ADC PARKS & GREENSPACE ARBORICULTURE

PLANNING APPLICATION: AB/116/15/T

ADDRESS: 38 Priory Road Arundel BN18 9EW

BRIEF DESCRIPTION: Reduce 1No. Oak tree by 4 metres

OAK TPOAB0103

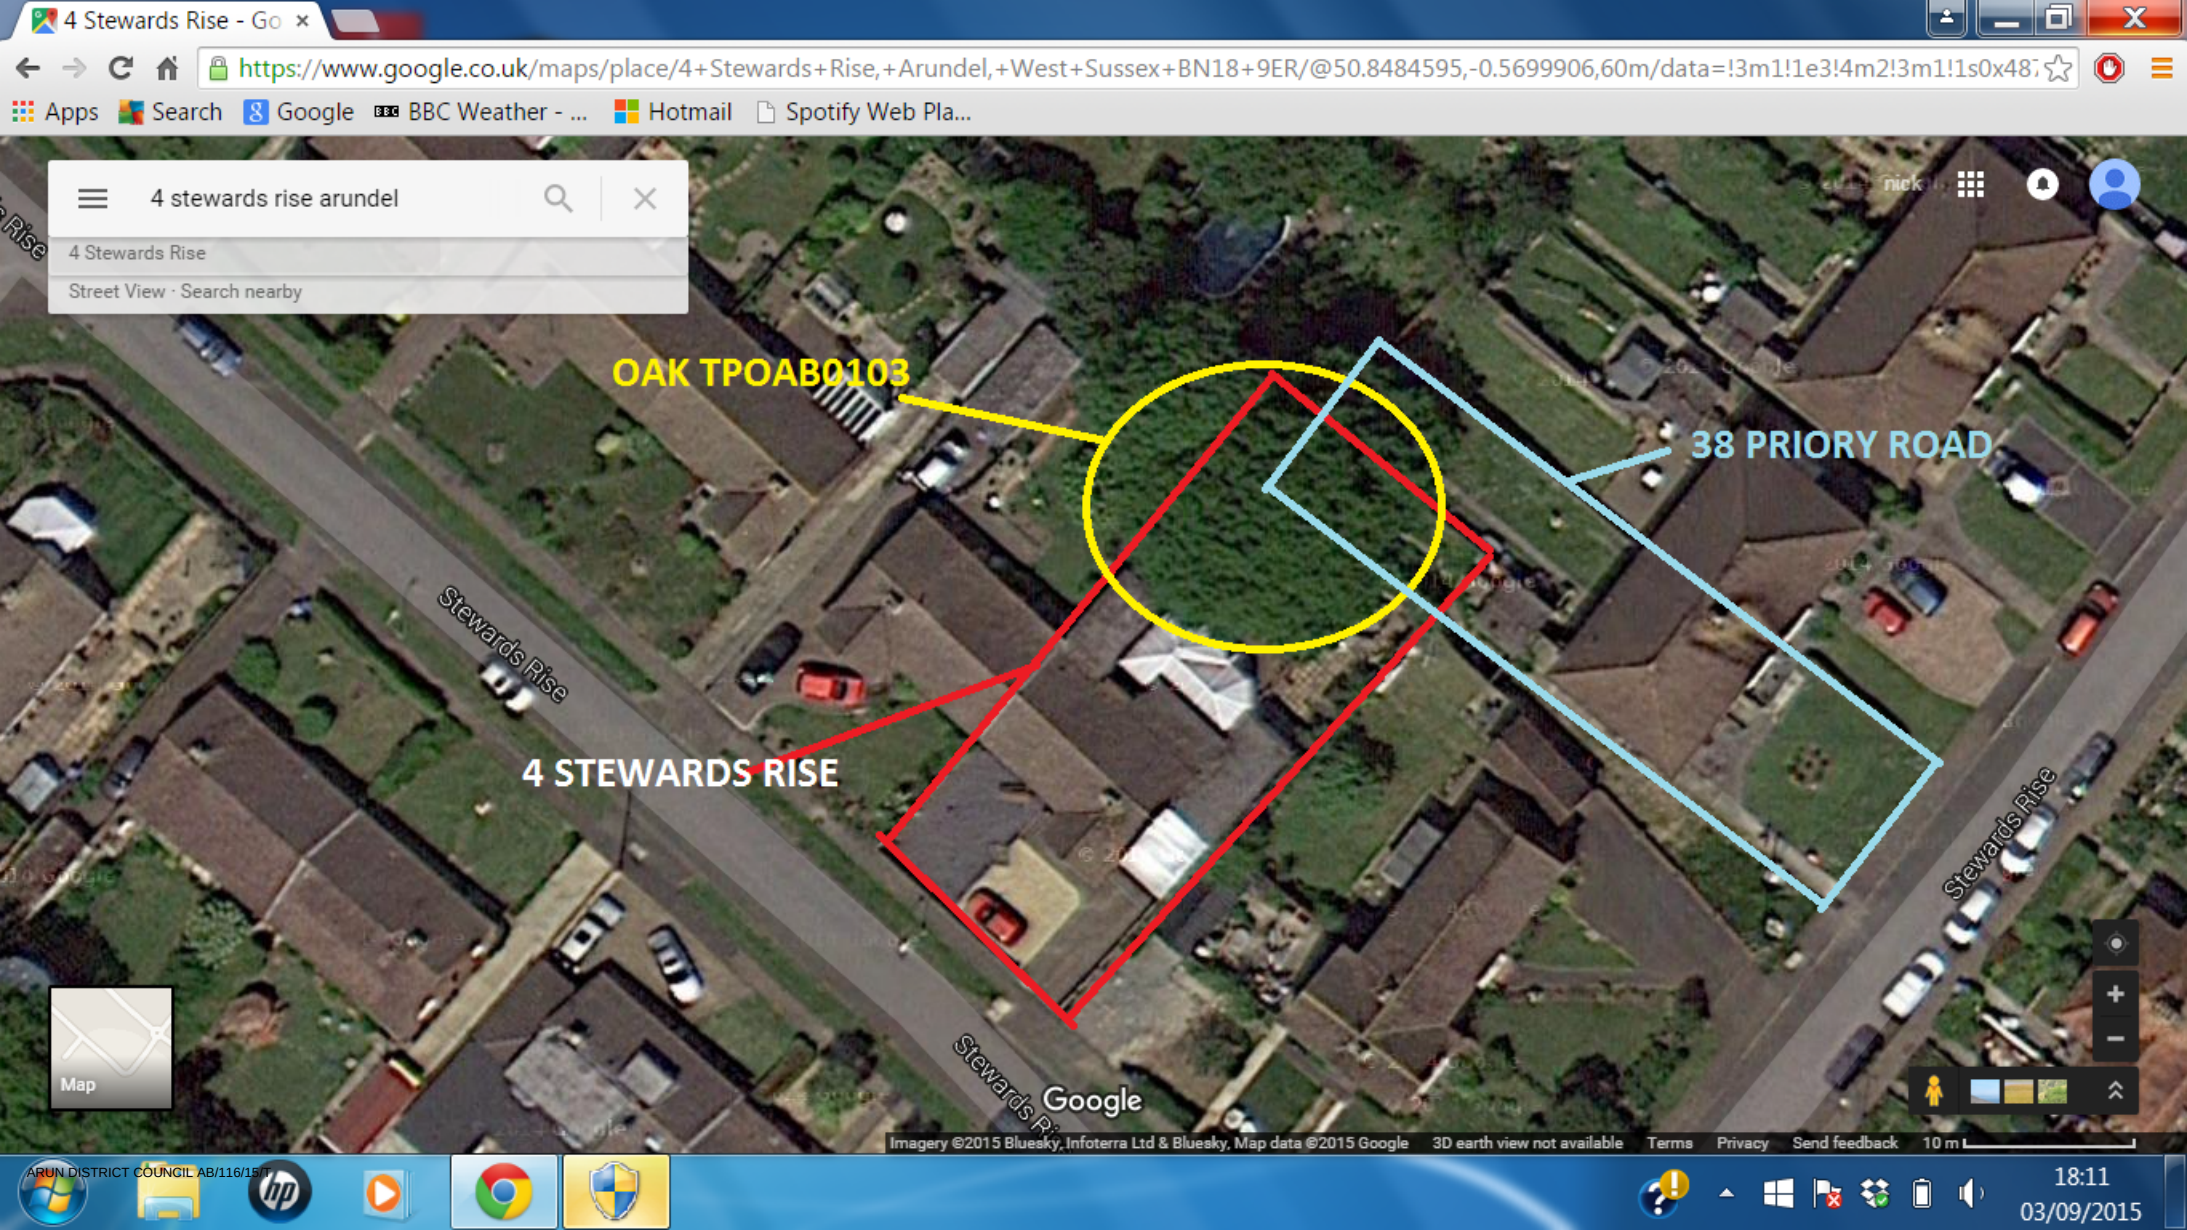
- The tree cited in this application is located in the rear garden of 38 Priory Road, Arundel. The tree is subject to active TPO order.
- The applicant has applied to reduce **T1** by 4 meters. From the site inspection it is evident that **T1** has some signs of selective historic formative pruning. It is also evident that the applicants request to reduce **T1** by 4 meters would surpass the established pruning points.

- I would object to the applicants request to perform a 4 meter crown reduction to T1. This proposed action is likely to lead to excessive pruning, leaving large pruning wounds that are susceptible to pathogenic establishment.
- I would however have no objections to the reduction of no more than 2 meters to T1, as it would be a more suitable for the outlined specimen.
- The following conditions must be adhered to when completing the proposed operation;

All side branches to be retained should be at least **1/3<sup>rd</sup>** in diameter of the removed branch. Pruning cuts must be flat and smooth, kept as small as possible by cutting at an optimum angle and should not exceed **100mm** in diameter.
